From: [REDACTED]
Sent: 25 April 2022 15:21
To: Planning
Subject: Re. Planning Proposal - Application No 3/2022/0317

We wish to raise the following points for the planning committee to consider in relation to the planning proposal for Land at Higher Standen Farm and Part Littlemoor Farm Clitheroe:

Proposed Bothy Plans and Sections

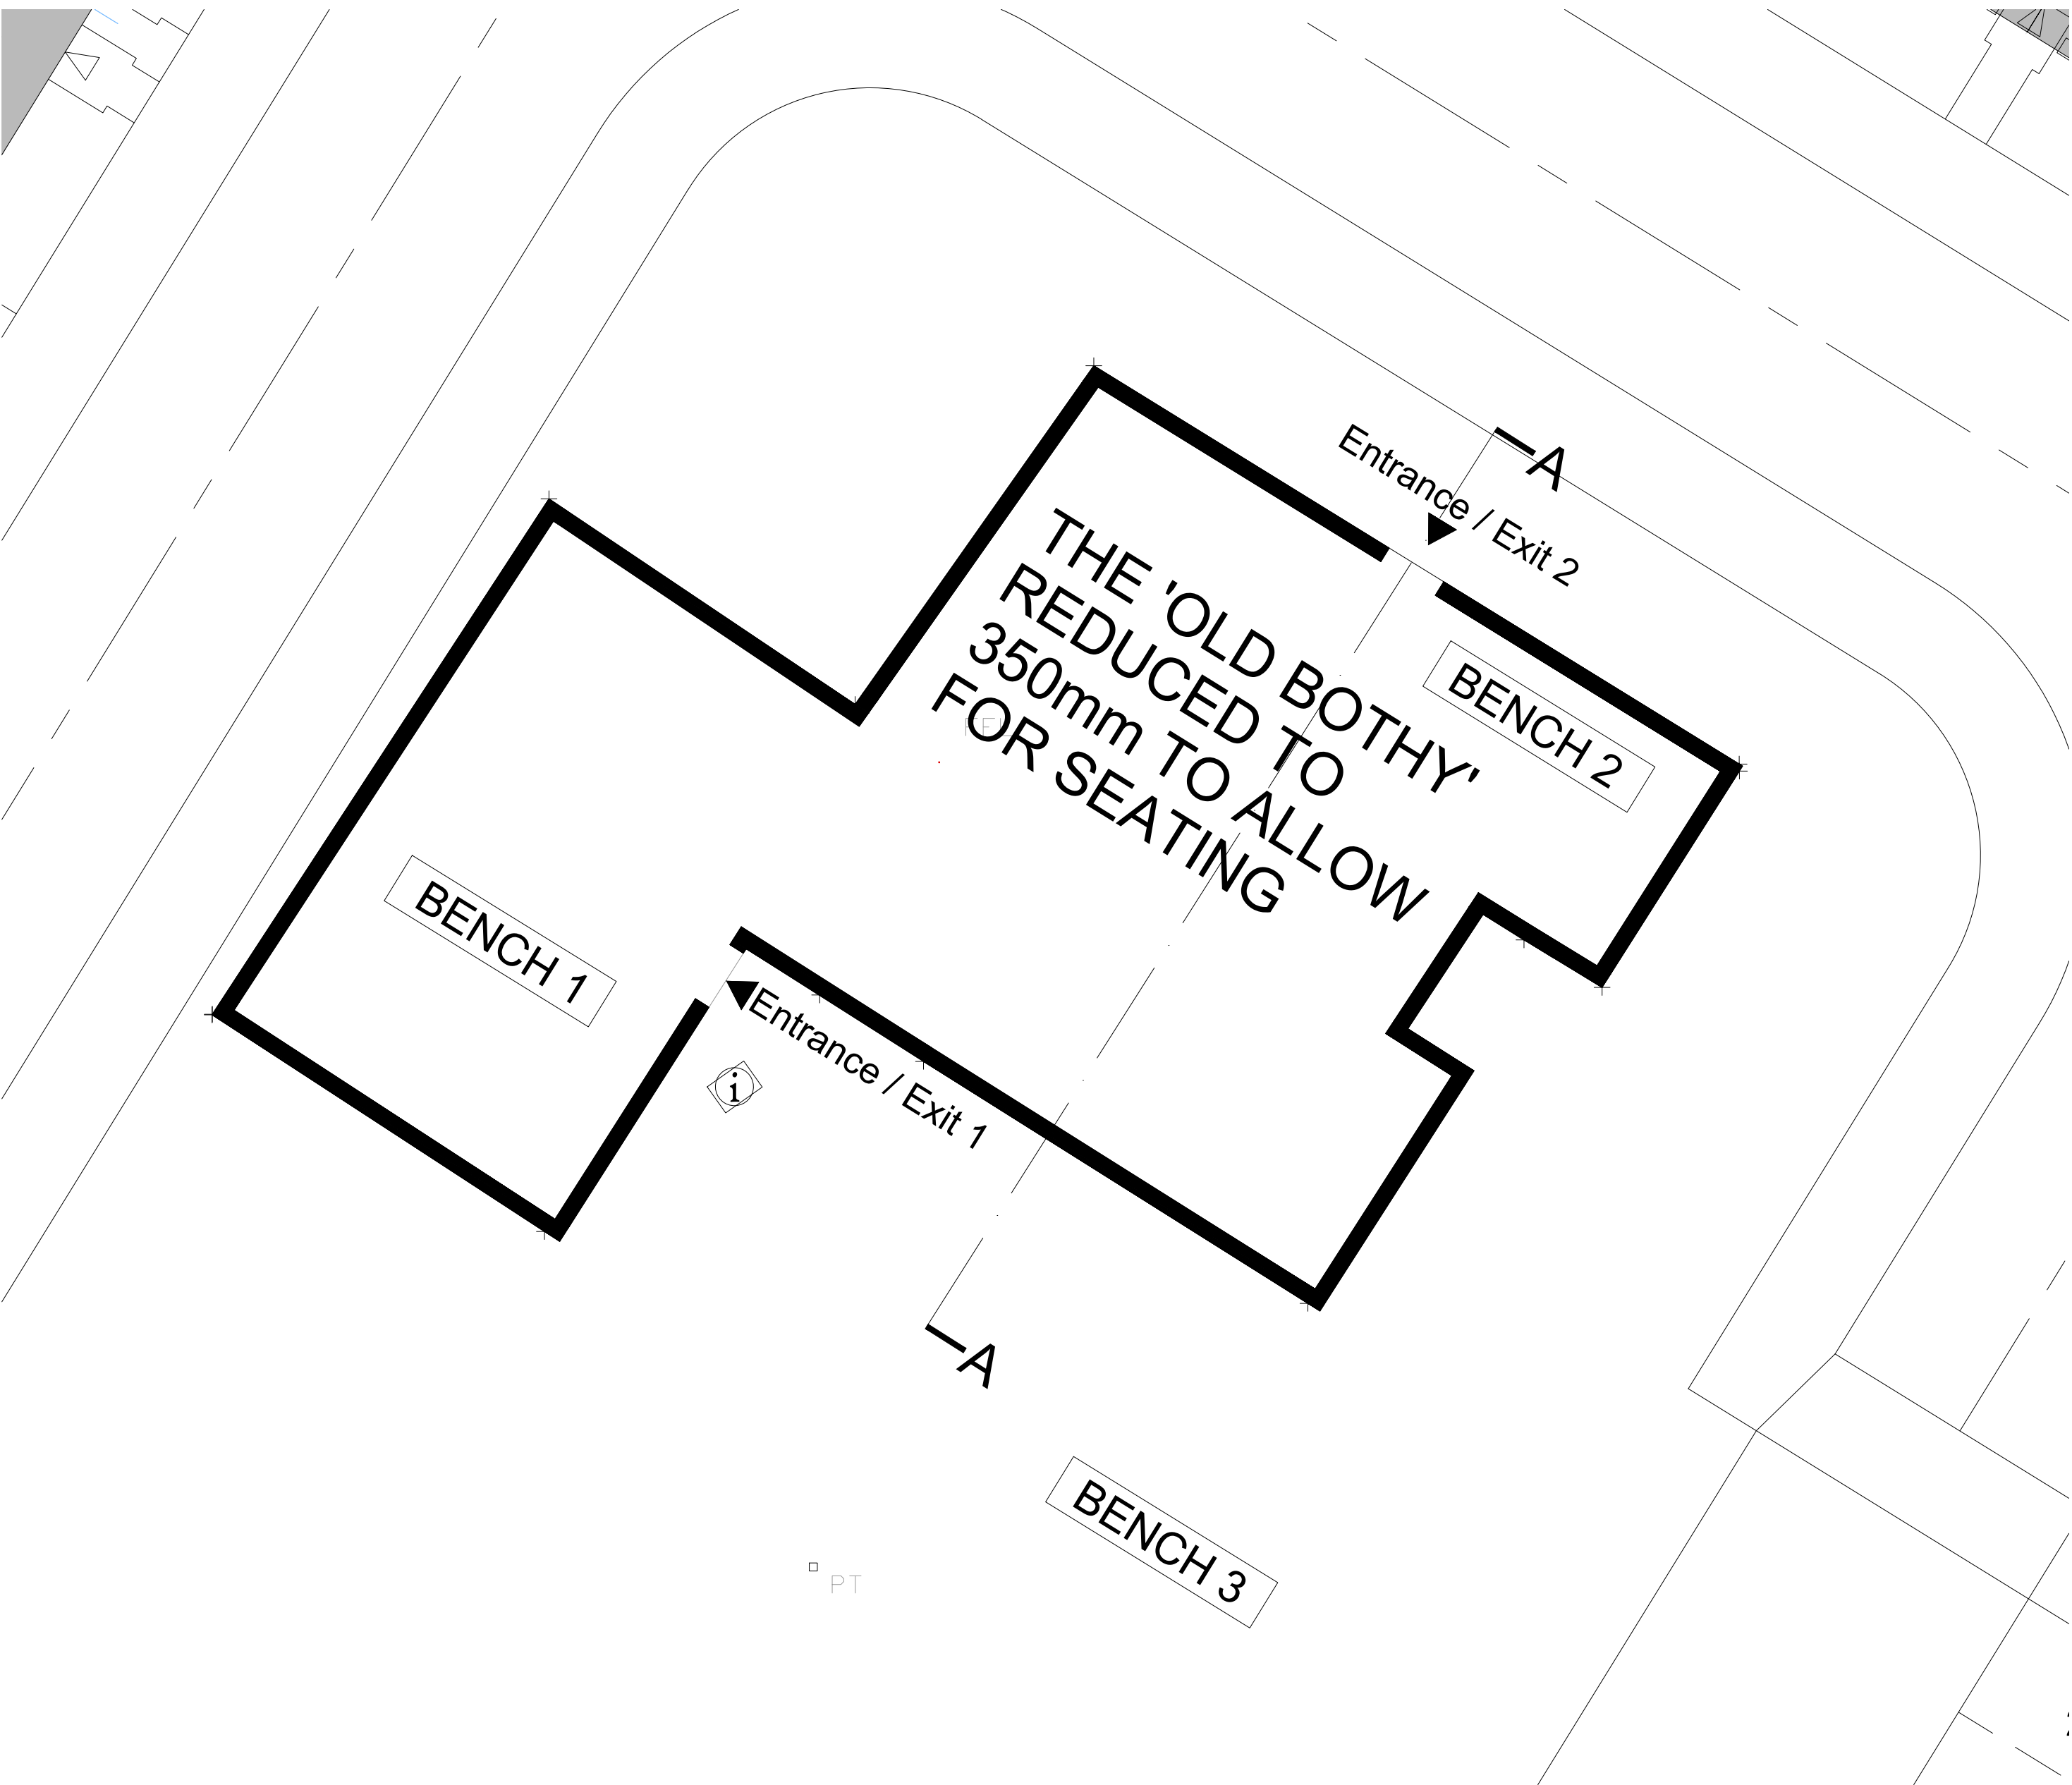
Can we be reassured that provision is made in good time before any development for the wildlife on the old bothay as we have reason to believe that there are owls, swifts, swallows and bats all nesting in an around there.

Storey Heights Plan Phase 6

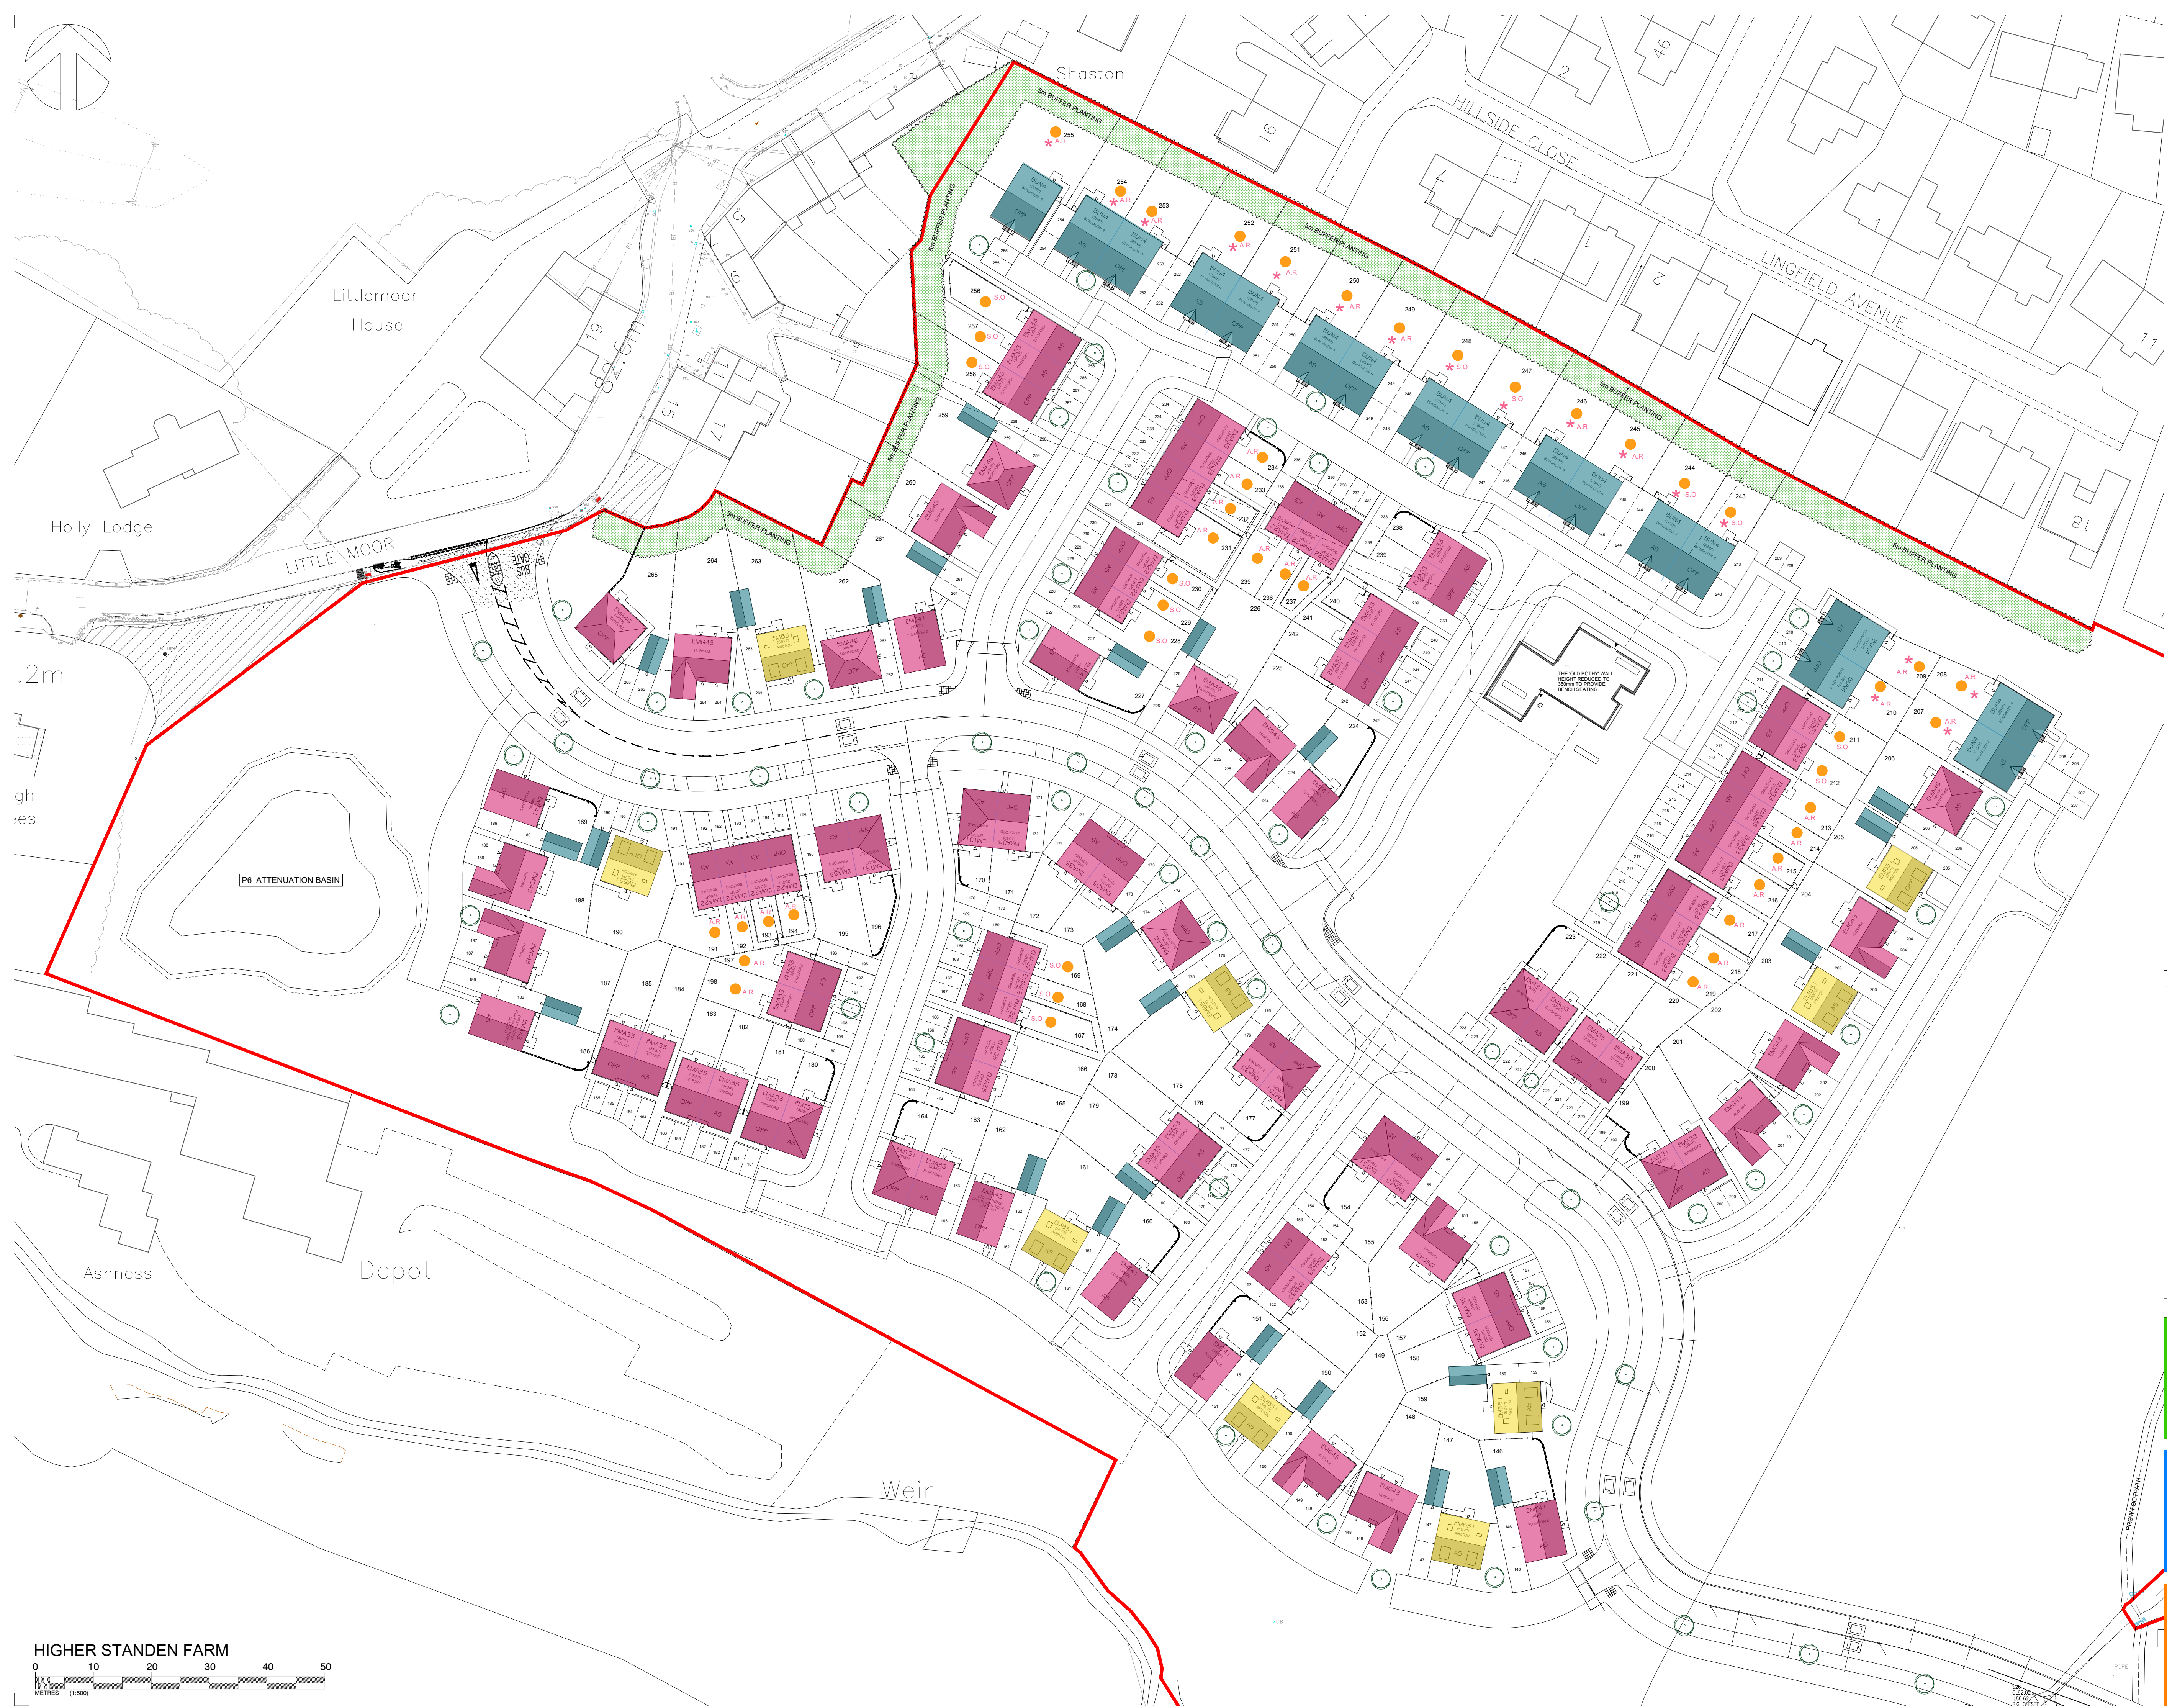
1. The buffer zone proposed on these new plans seems to have reduced from the original outline planning approved which specified a 50m buffer zone along the rear of the houses on Littlemoor road. The proposed buffer zone looks to be 10m, possibly 15m wide at best and not consistent width for the house near the proposed Littlemoor road entrance has a reduced buffer zone. Please could this be looked into and the 50m approved buffer zone insisted on being maintained.

2. Please could we request that the buffer zone mentioned in point 1 is planted up as soon as possible with trees so that by the time the development work starts there is already some cover and establishment of a sight "buffer". Please could the trees proposed to be removed from the small wood where the proposed Littlemoor road entrance is due to go be transplanted and put in the buffer zone starting at the road side where the plans show the first house to be directly in line with the windows of No.15. Thus by using these mature trees here a privacy, sight "buffer" is soon established.
